From: stephen jupp [REDACTED]
Sent: 05 May 2015 15:54
To: Simon Davis
Subject: Re: App BE/41/15/DOC - 346 Chichester Road, Bersted

I've had to chase for WSCC Highways comments on your DOC application. I understand these were previously issued but never came to me. They have asked for a modification to the CMP to include that where the situation arises where a vehicle is required to reverse out of the site onto Chichester

Construction Management Plan

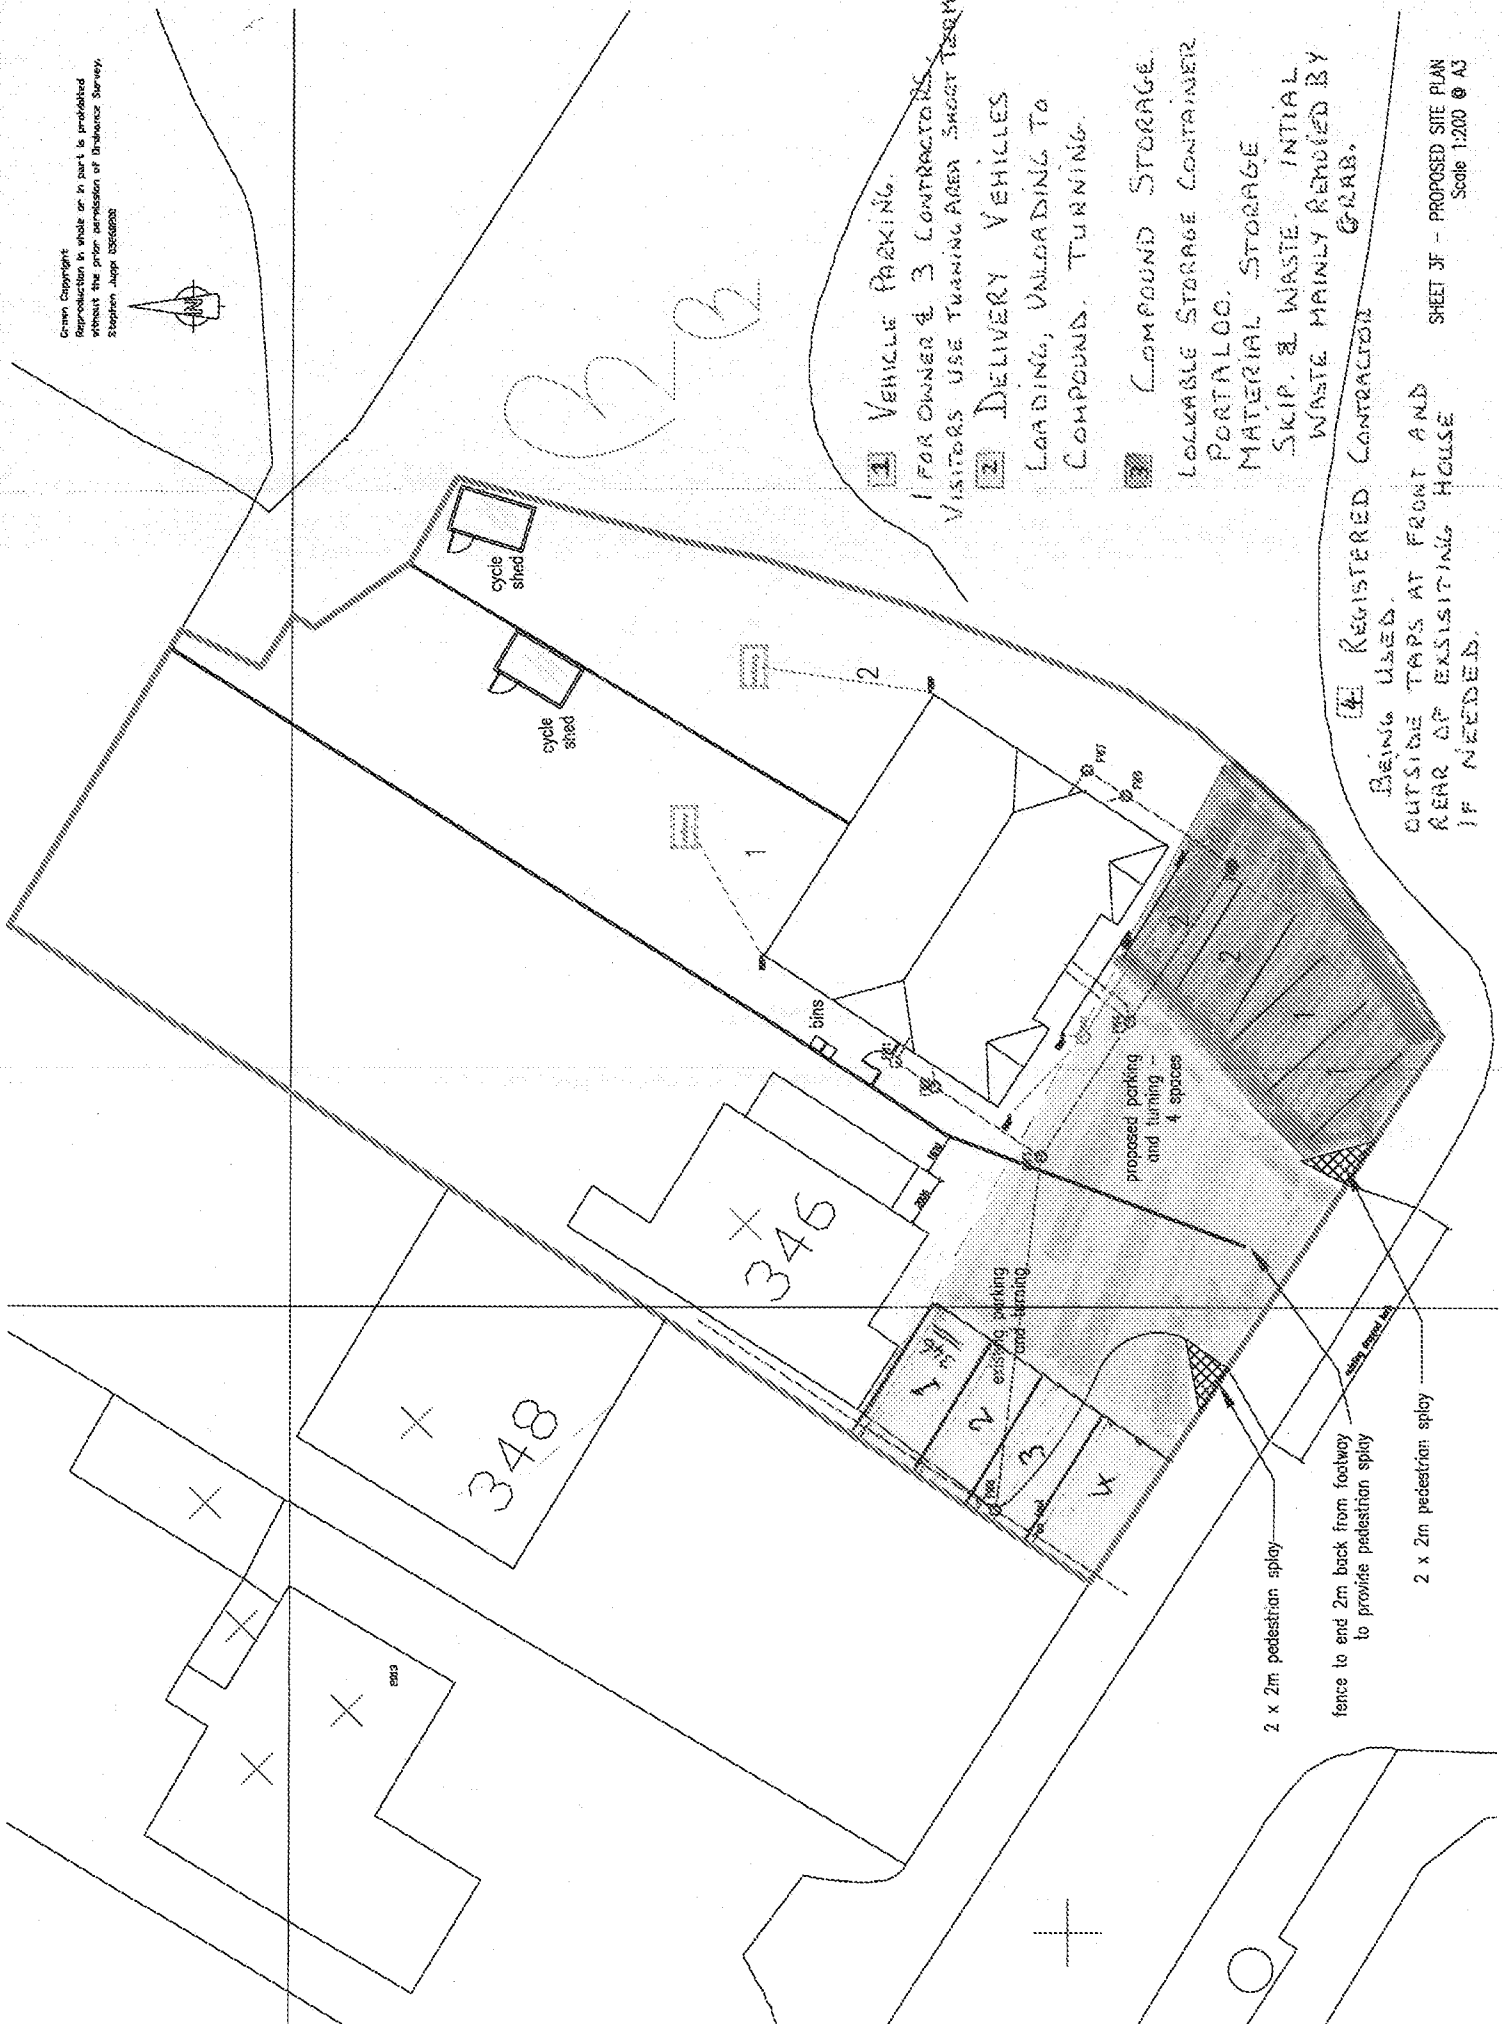
Road, that this manoeuvre be undertaken with the use of a trained banksman. Could you amend the submitted Plan and email me a new copy. I can then issue the decision on all three conditions.

simon
should be a text box inserted on plan as attached
steve
